Planning Services Sign Permit Review Form

Date of Submittal	Application Number	Applicant	Landowner
9/15/2021	SIGN2109-0004	Advance Signs & Service s	Pioneer Companies LLC

Contact Person	Contact Number	Sign Location	PIN Number
Debbie Landell	919-639-4666	5545 Ray Rd. Spring Lake	0505-48-7310.000

SITE/LANDSCAPE
 PLAN

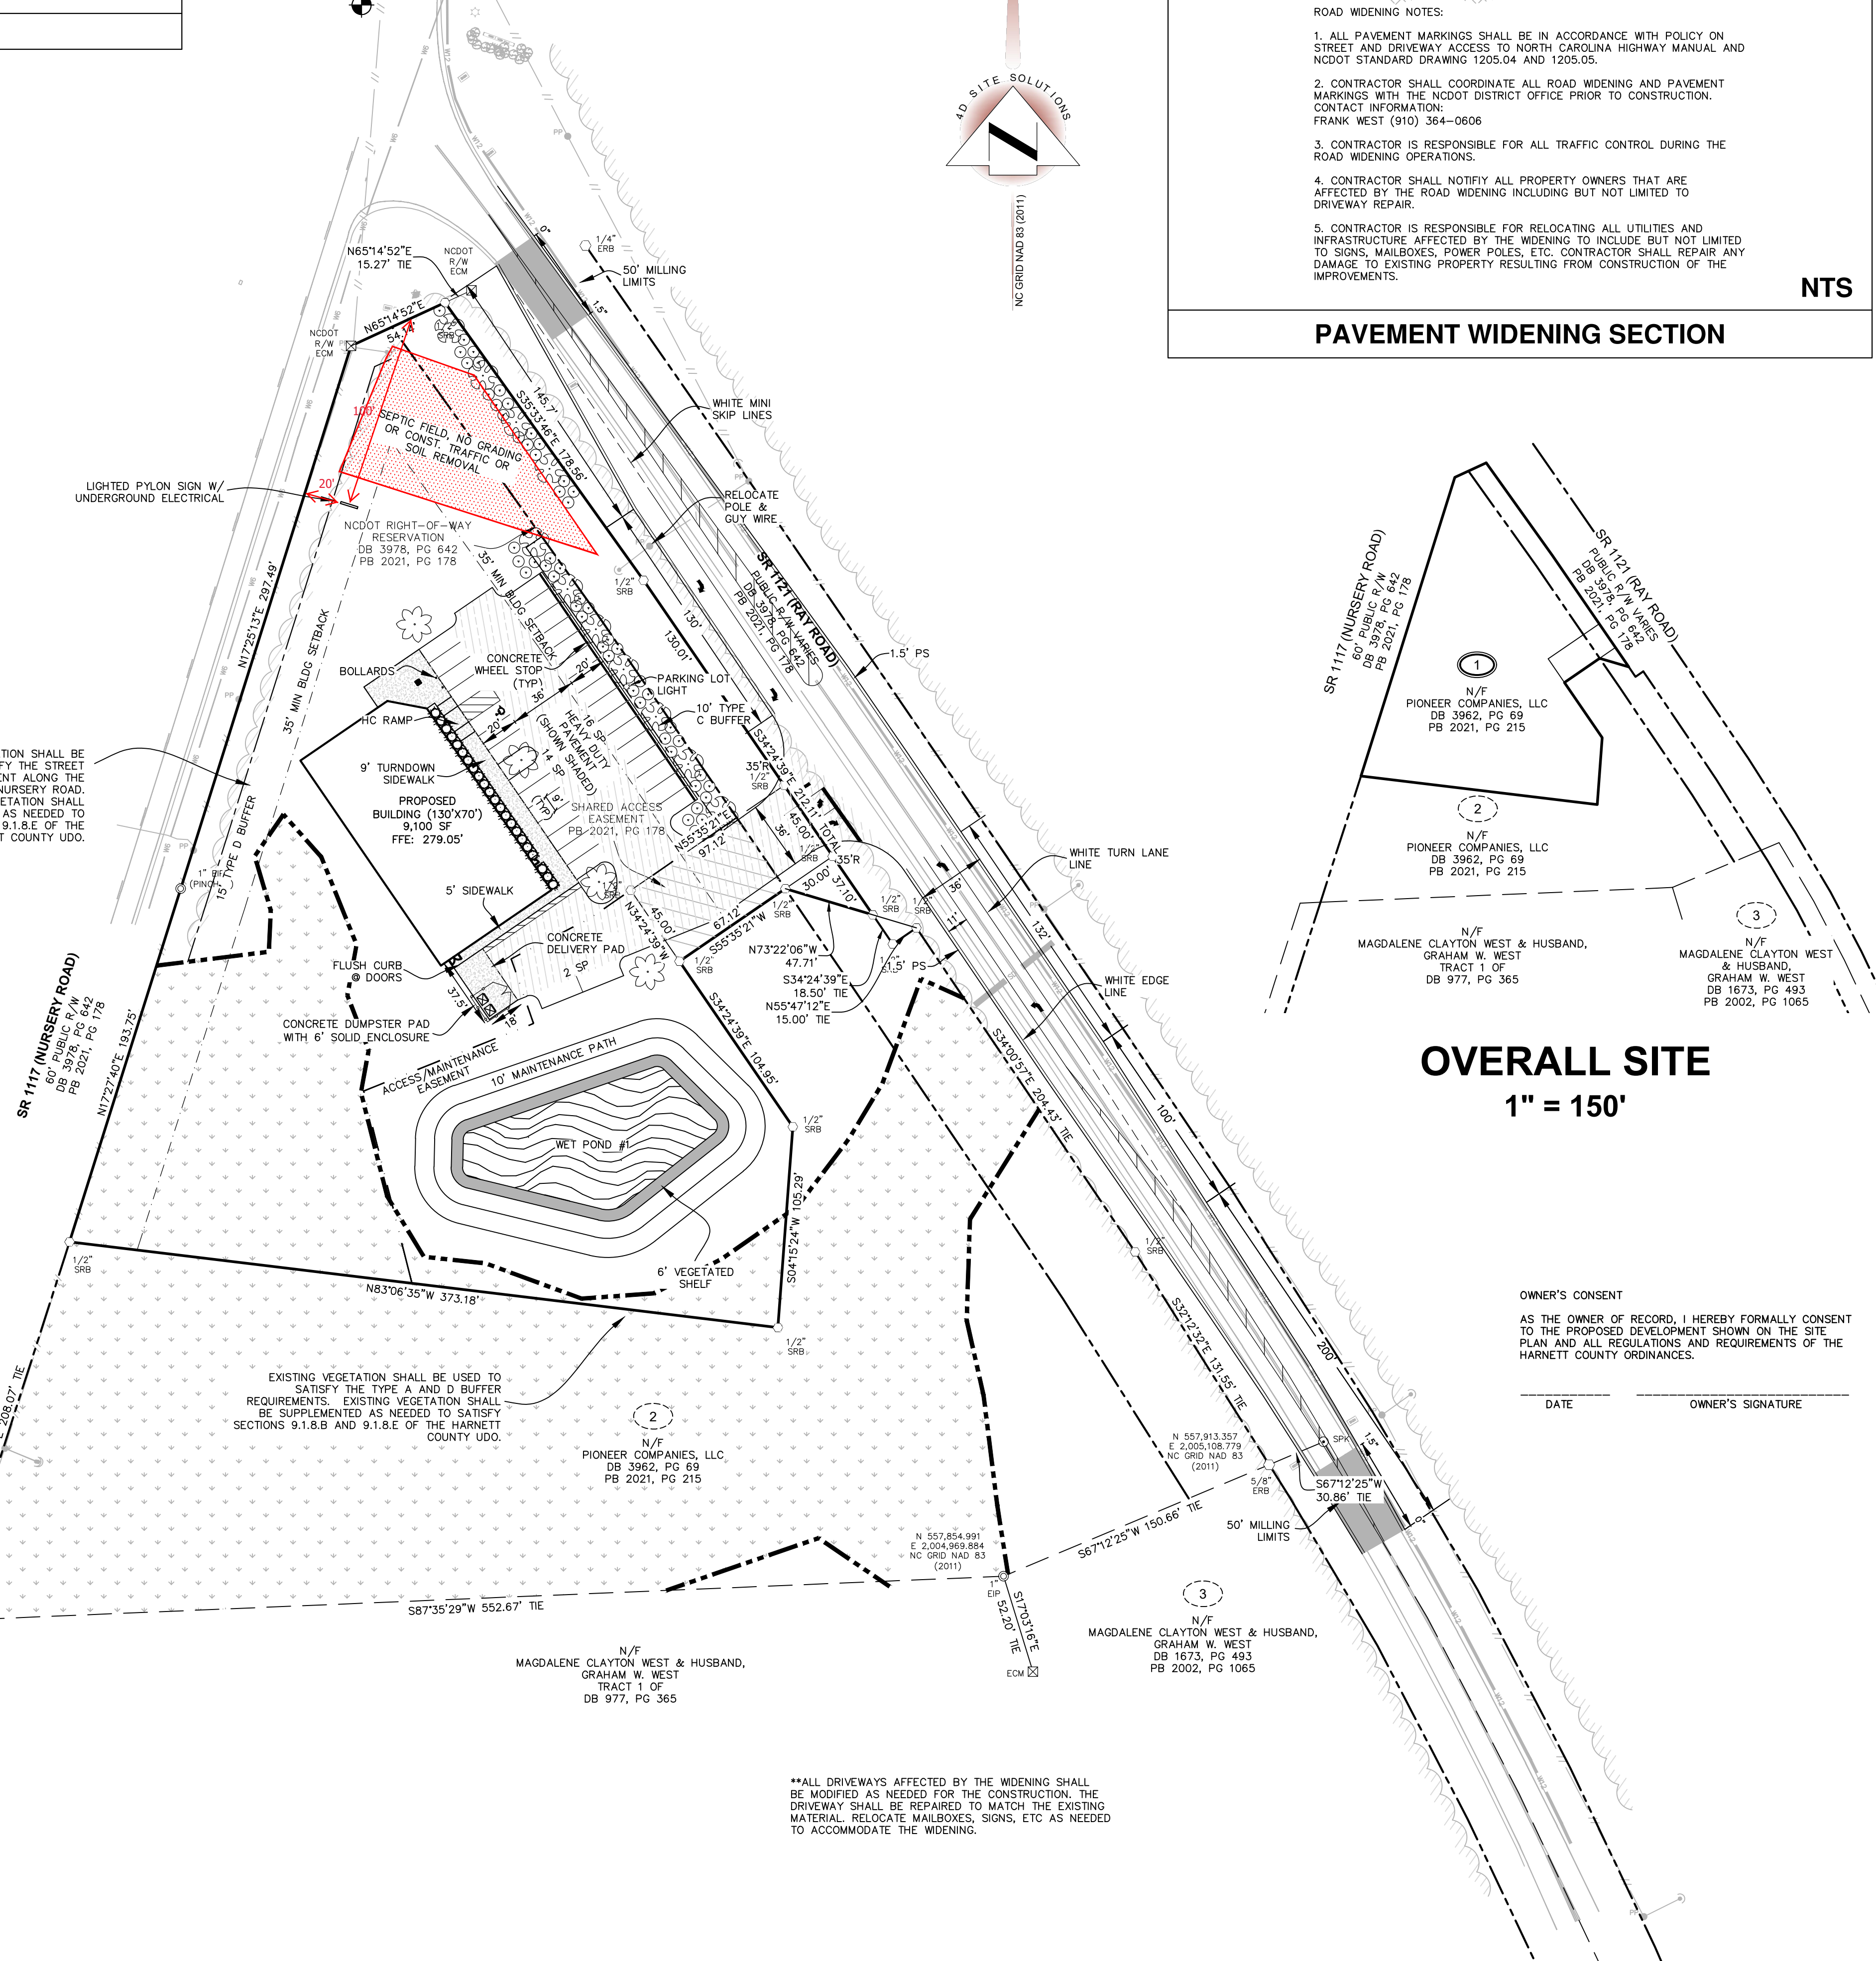
Comments	1. Please provide the setbacks from the proposed sign to the property lines and the RW on the site plan.
----------	--
